Re: Planning Application 19/0278

Address: Land adj Lower Cock Hill Barn Hothersall Lane Ribchester PR3
2XB

Description: Change of use of land for horses, construction of new vehicular
access, stables and hard standing.

Simon Hardie
Highways Development Control
Lancashire County Council

Proposed Site Plan

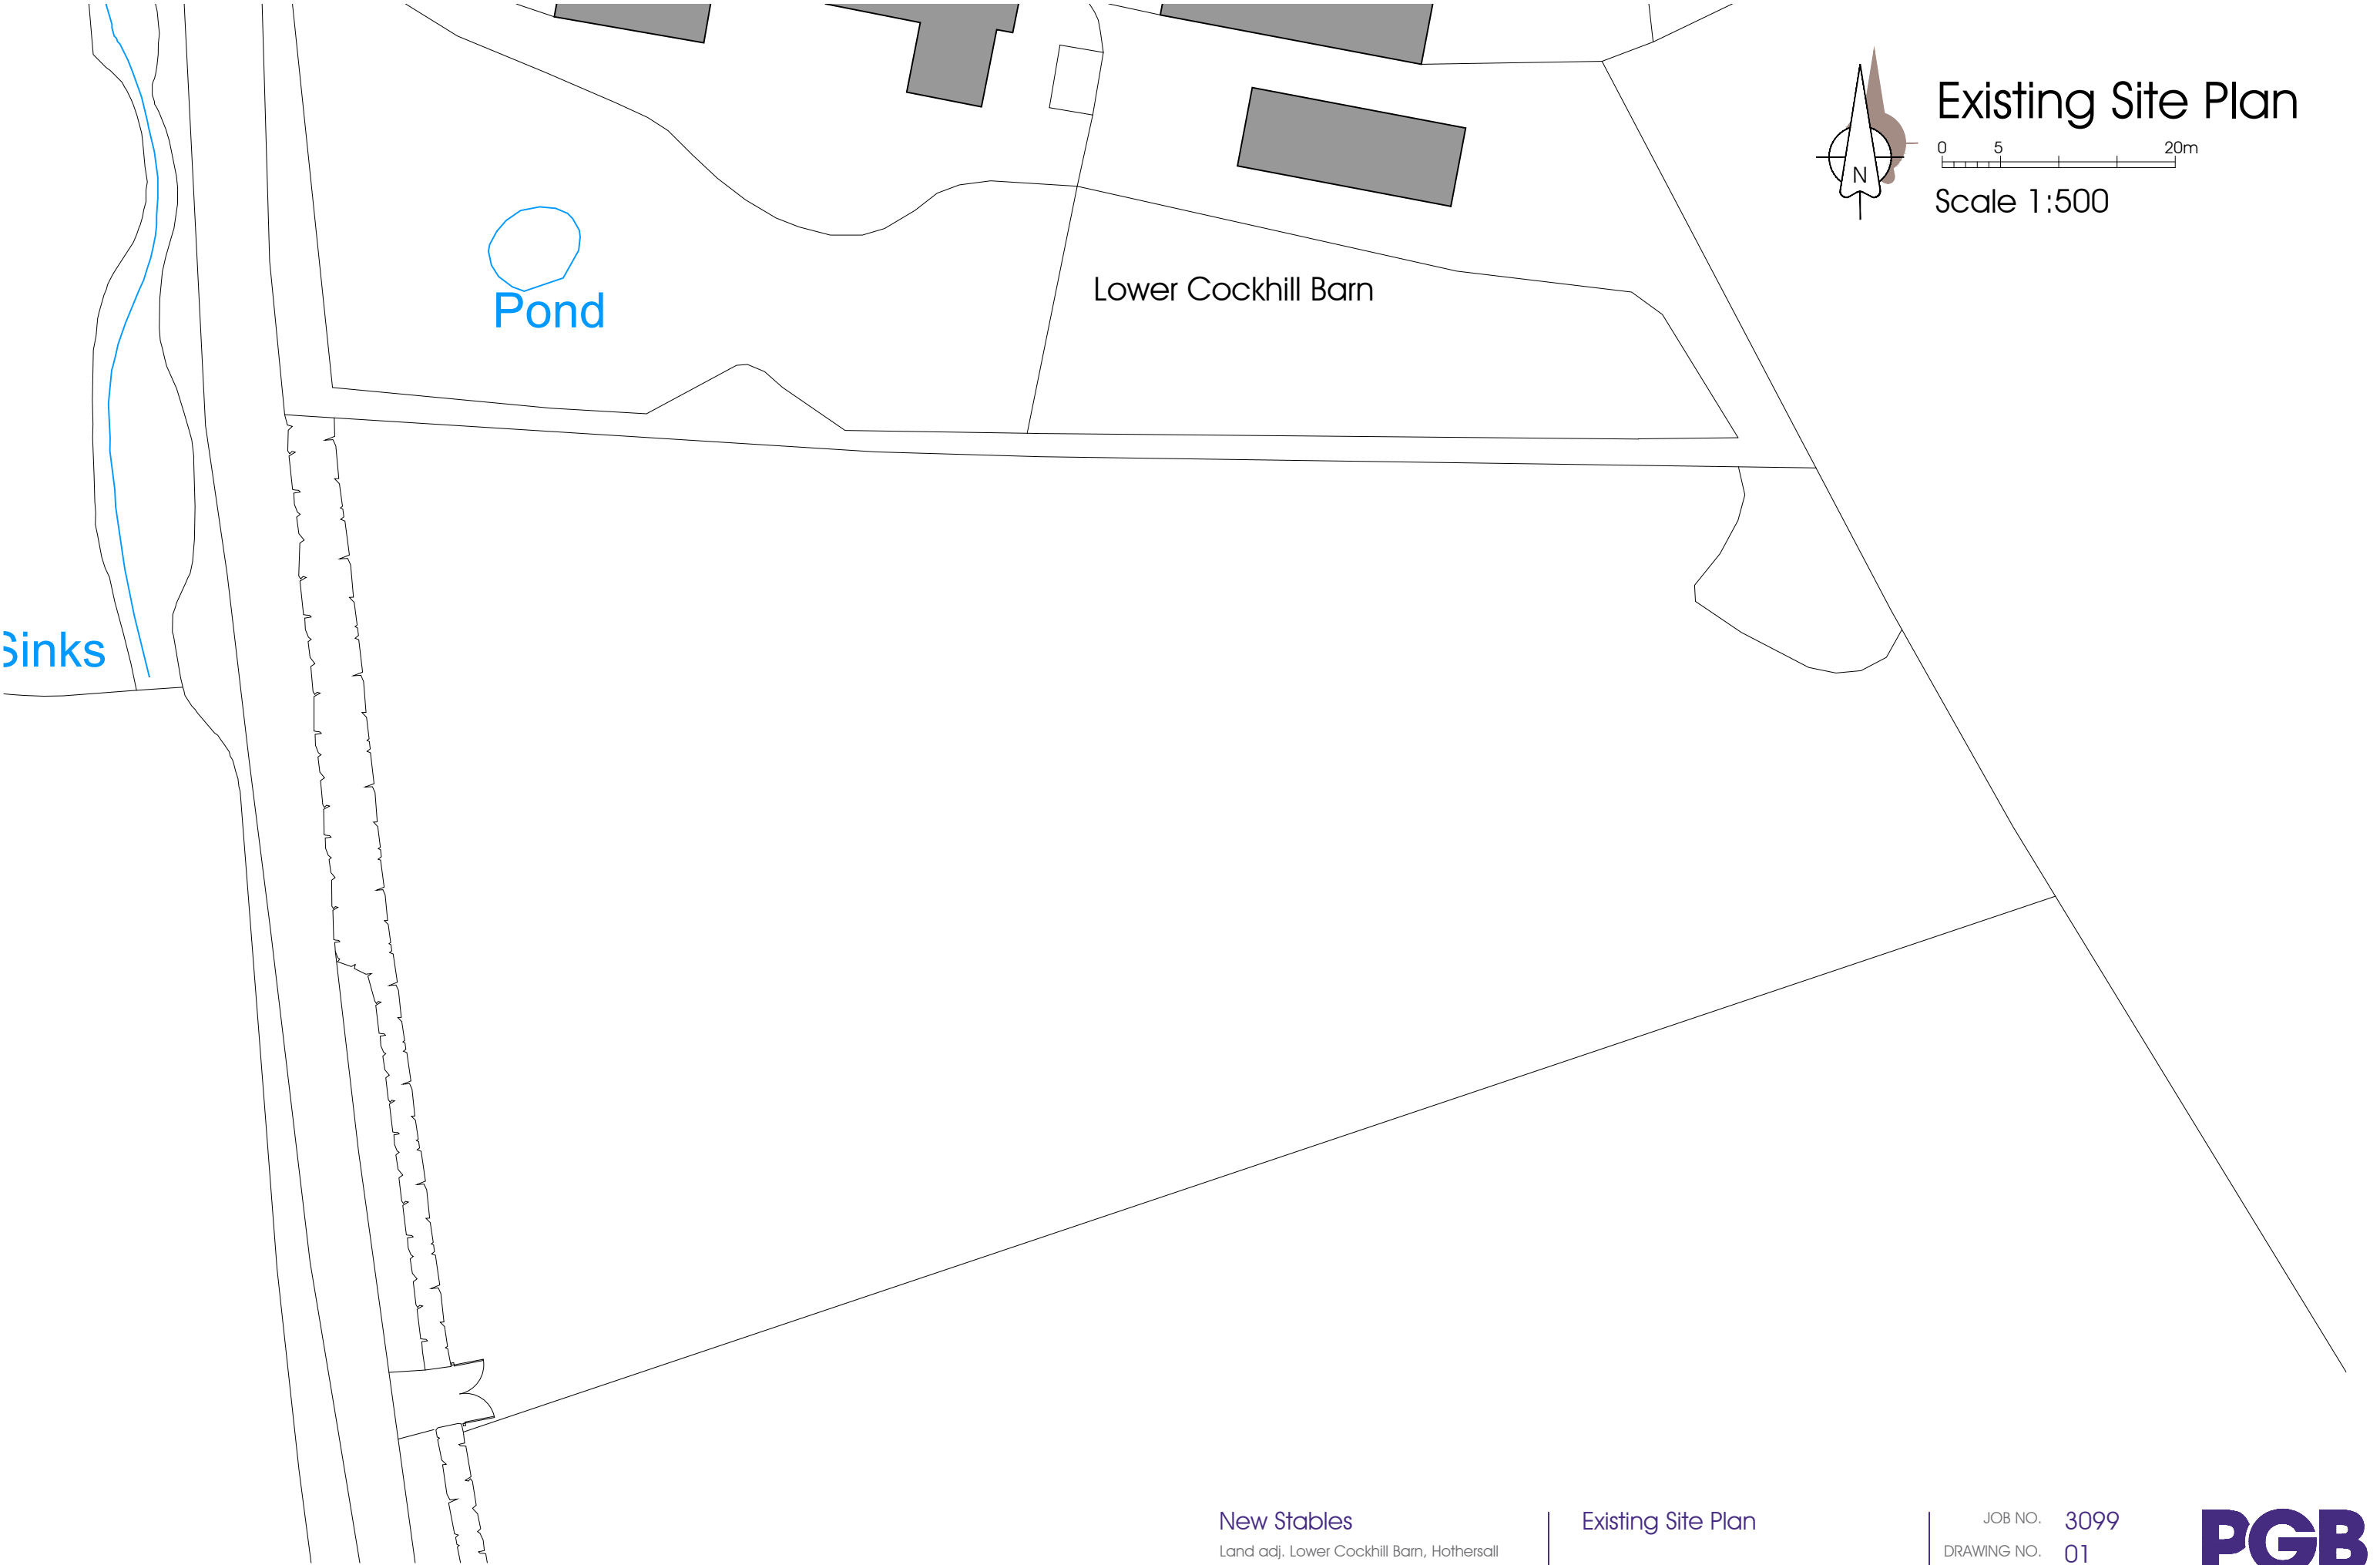
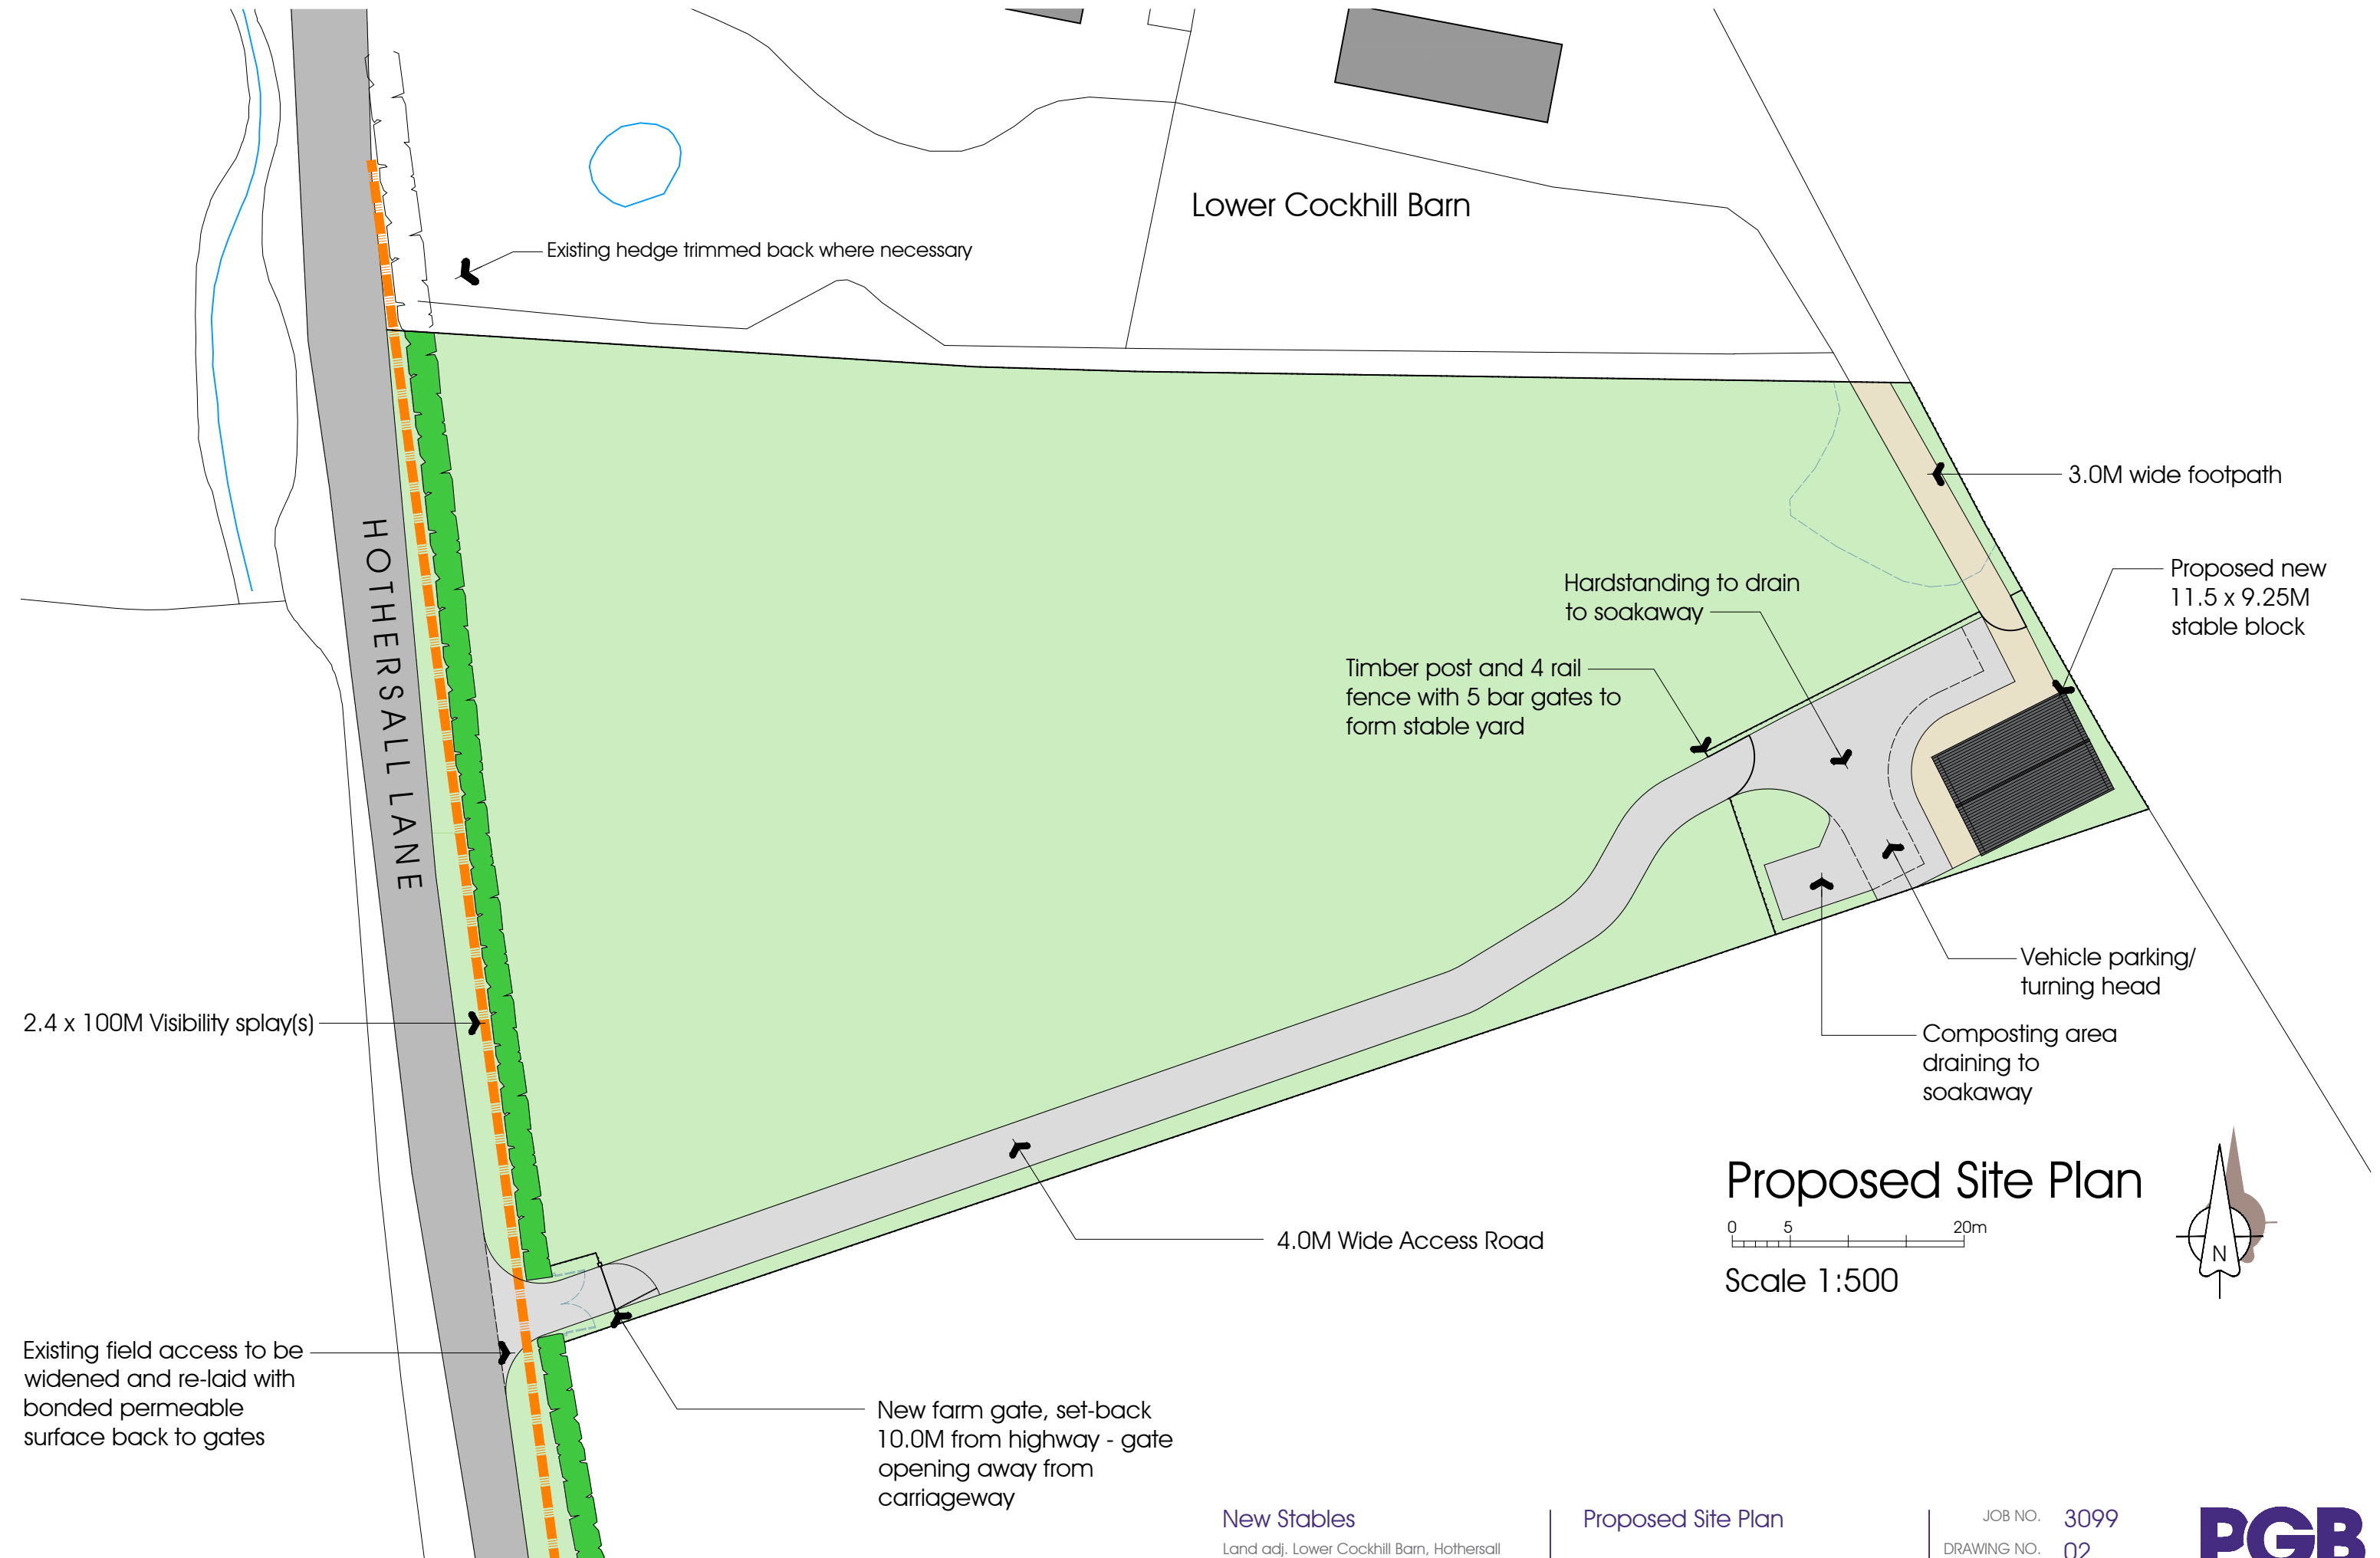
1. Before the access is used for vehicular purposes, that part of the access
extending from the highway boundary to the gates shall be appropriately
paved in tarmacadam, concrete, block pavements, or other approved materials.
Reasons: To prevent loose surface material from being carried on to the public
highway thus causing a potential source of danger to other road users.
